Submission Form

Epping to Thornleigh Third Track Proposal. Application number SSI 5132.

Figure 5.5 Artist's impression of new elevated concourse at Cheltenham Station looking south from The Crescent (indicated circle)

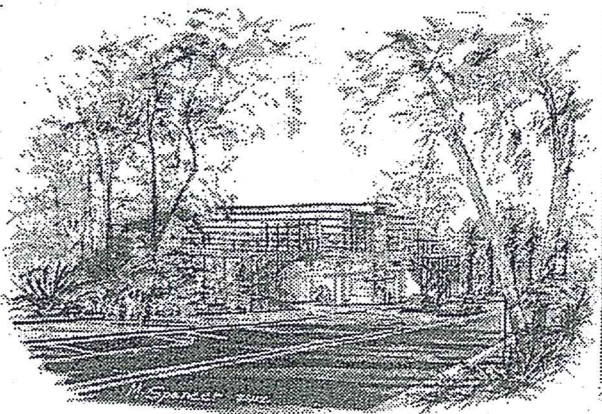
- The proposed redevelopment of Cheltenham Station shows no regard for the HCA. The visual impact of the proposed 13m high glass and steel concourse is totally unacceptable in this HCA.

Concept design drawing of proposed changes to Beecroft Station (Parsons Brinckerhoff 9/3/12). Former side platform shaded in pink.

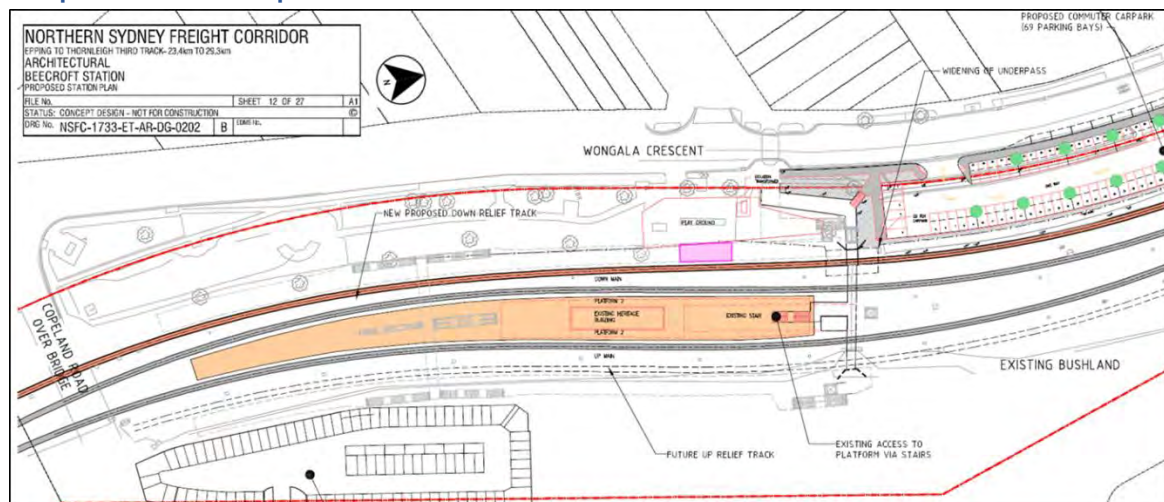
- There has been inadequate assessment of the project's impact on the fabric of the Beecroft Cheltenham Heritage Conservation Area (HCA).
- The plan given for Beecroft Railway station Precinct is vague. The relationship to the trees, playground and original 1895 platform located south of the present station is not shown. A fourth track is shown on the eastern side. The plan does not include urgently needed lifts to allow disabled access at Beecroft Station.
